Application No: M/71/20/HH
Site Address: 18 Sea Way Elmer Middleton-On-Sea PO22 6JY
Description of works: Construction of first floor dormer to provide enlarged bathroom and wardrobe/storage, construction of detached garage

Thank you for your internet representation made on 15th October 2020 which has been recorded as an objection with the comments as follows:

DRAWING TITLE
**PROPOSED DETACHED GARAGE
FLOOR PLAN AND ELEVATIONS**

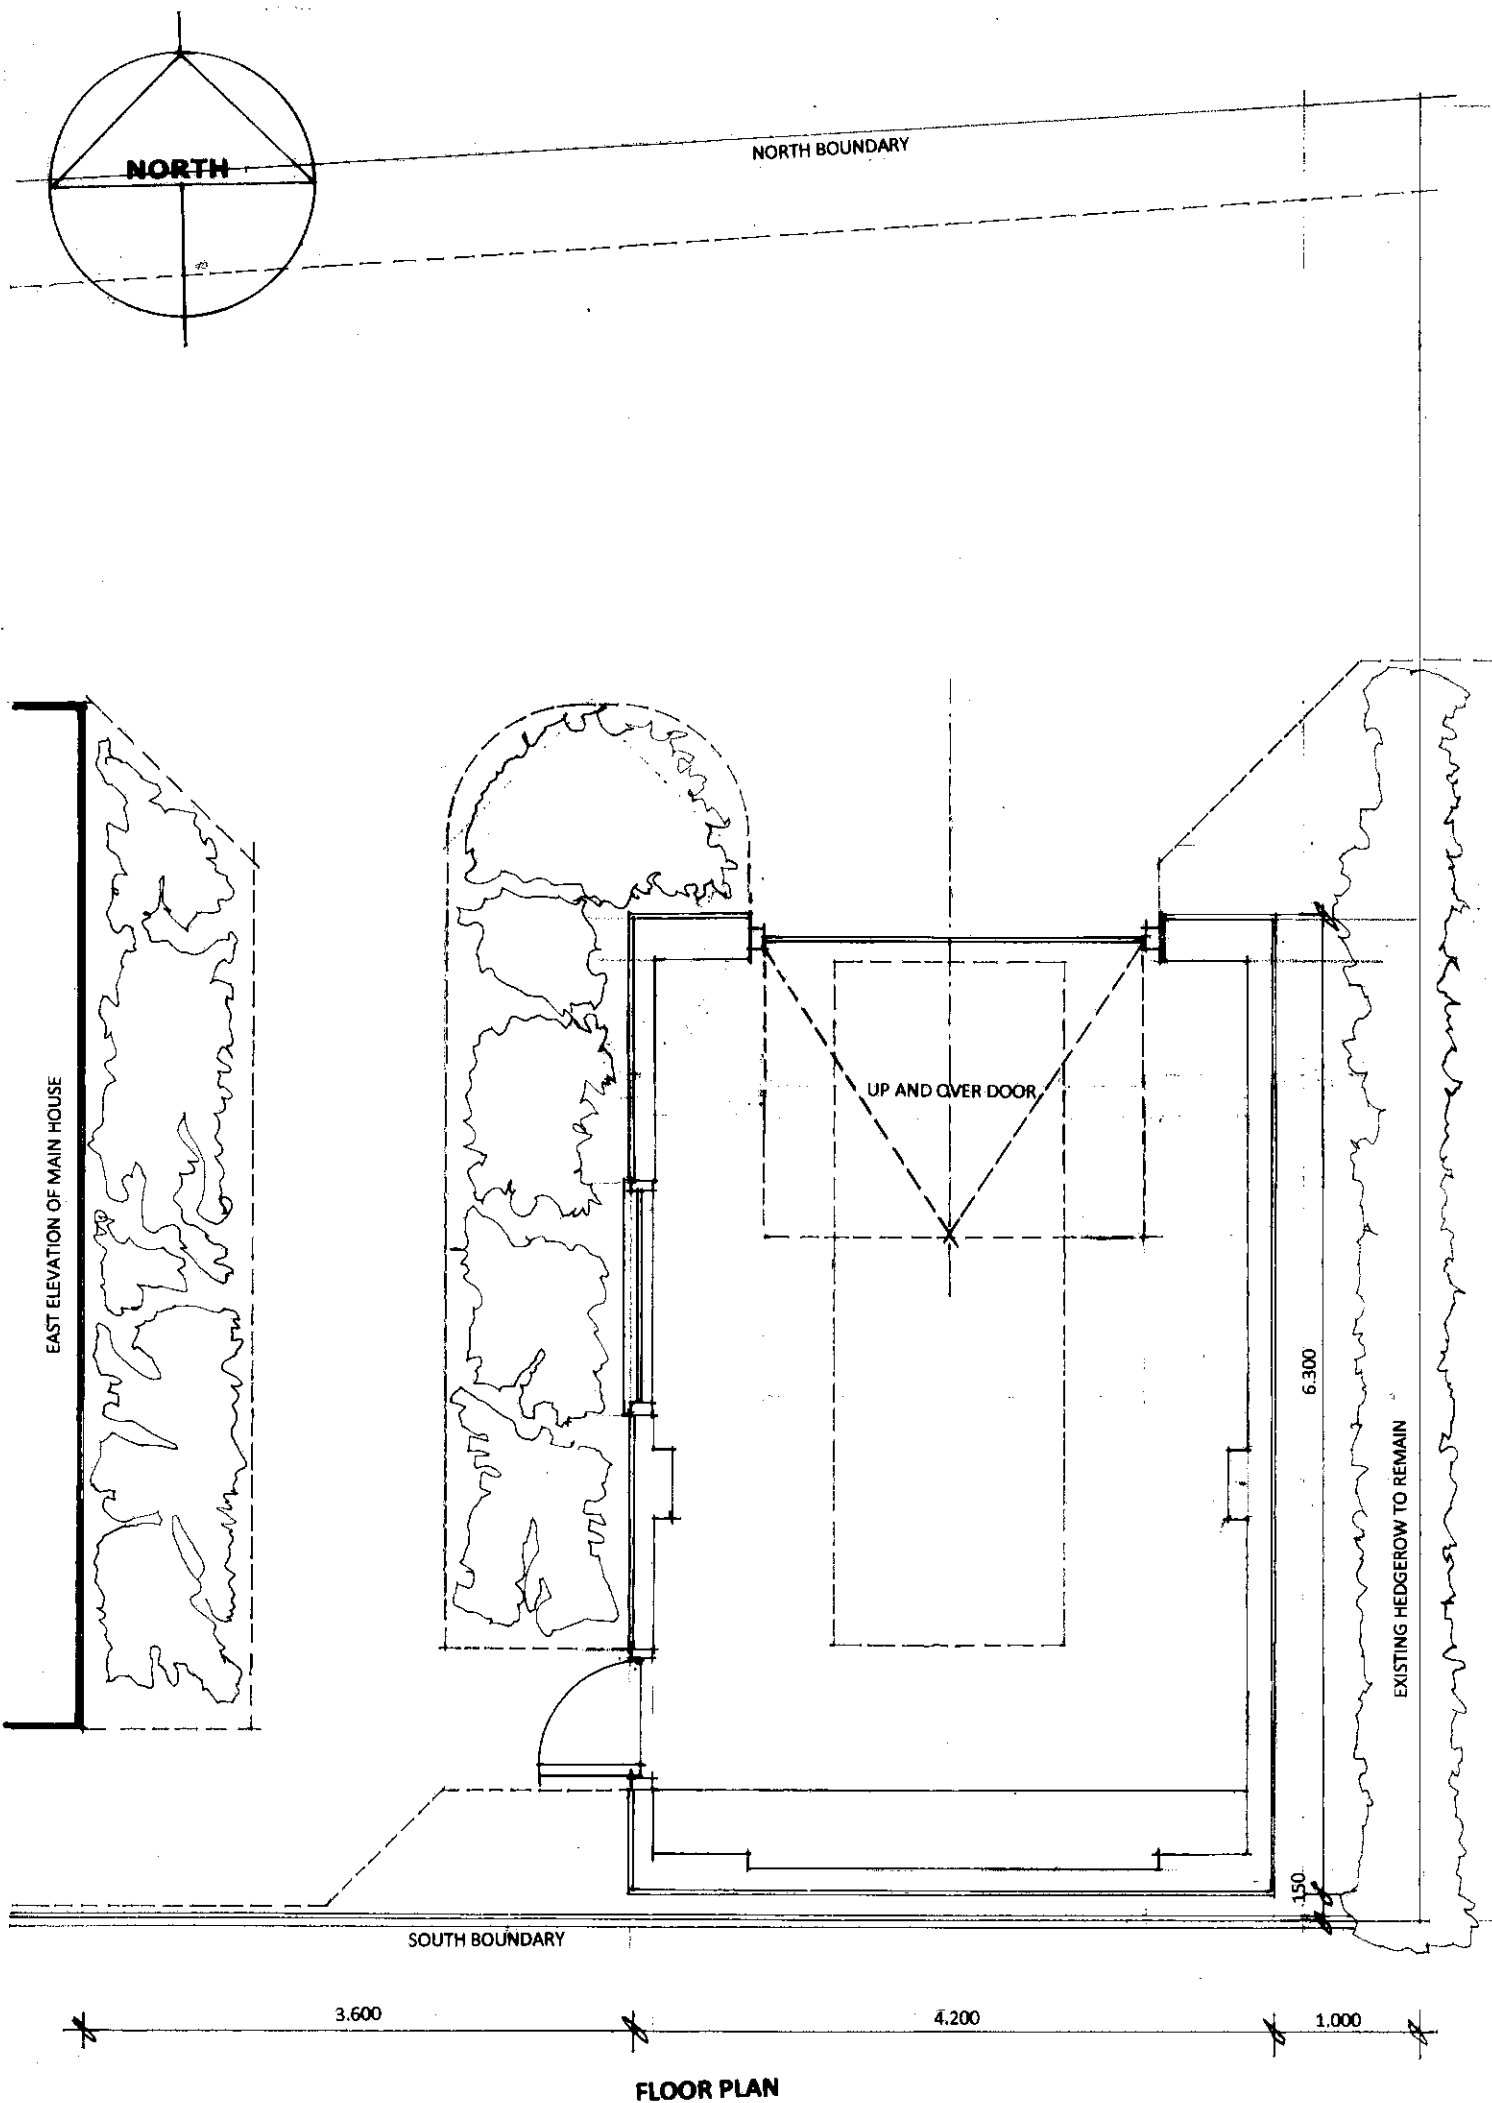
Also, the property is known for standing water in inclement weather and the loss of over 26 square metres of natural drainage is a cause for extreme concern.

DRAWING TITLE
**PROPOSED DETACHED GARAGE
ROOF PLAN AND ELEVATIONS**

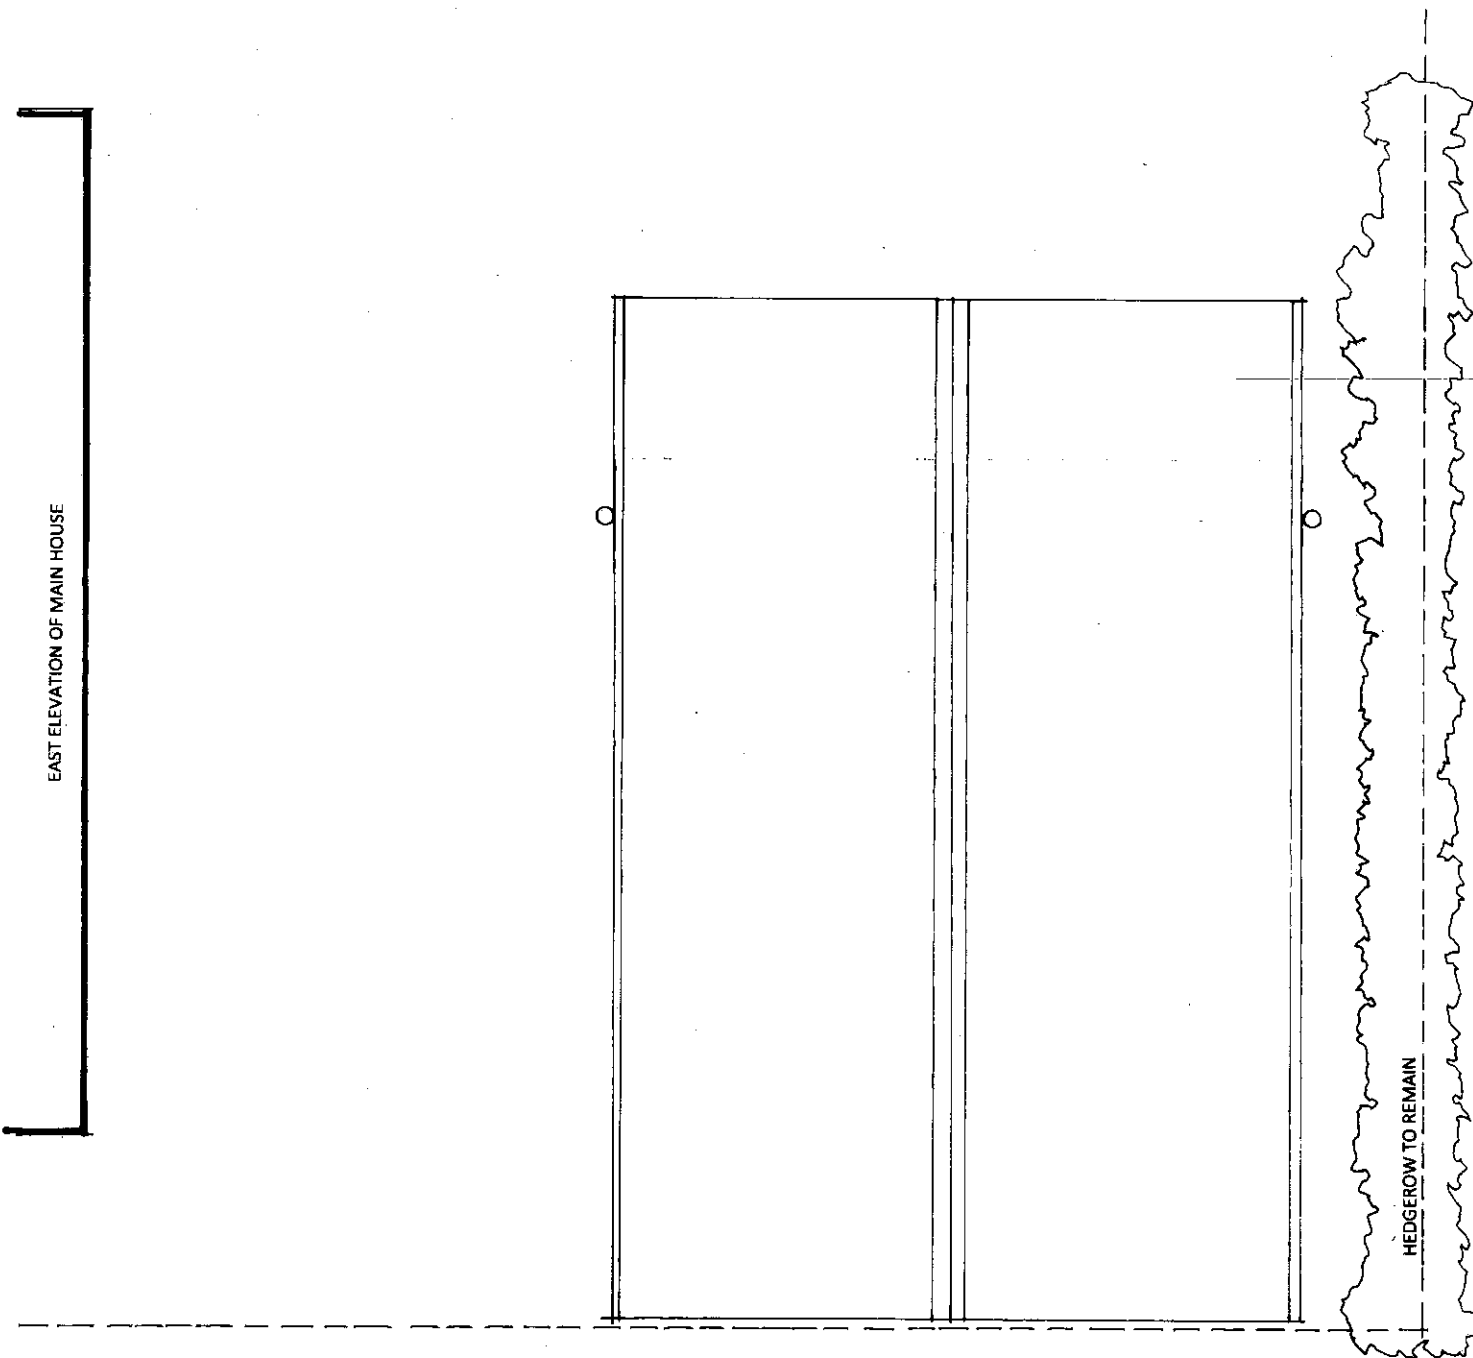
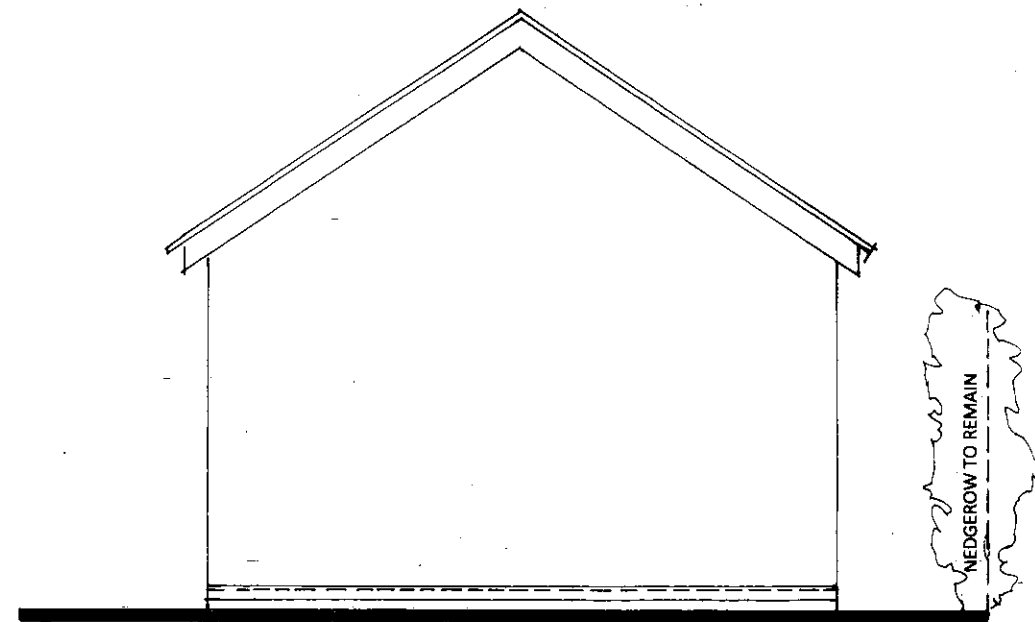
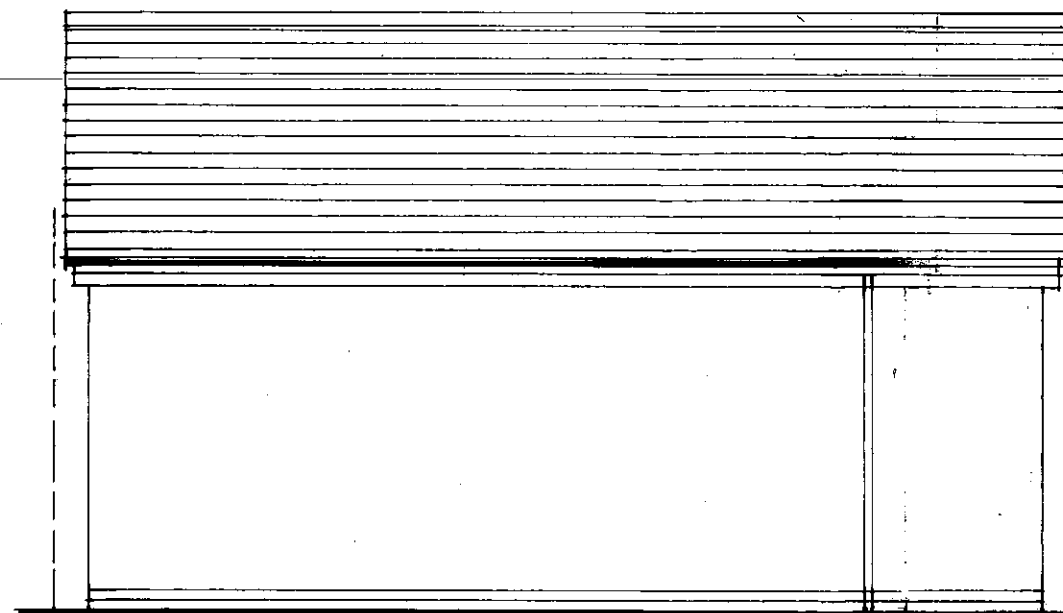
Having seen the plans and the proposed location of the garage, the design is simply not in keeping with the surrounding properties.

I regularly walk on the green to the front of the property and the orientation is such that I will simply see an ugly expanse of roof above the hedge line to the side of the road, as will anyone else who is passing by. The bungalow itself will be totally obscured over virtually the entire width of the plot.

The drawings submitted indicate it will have a ridge height of 4 metres.
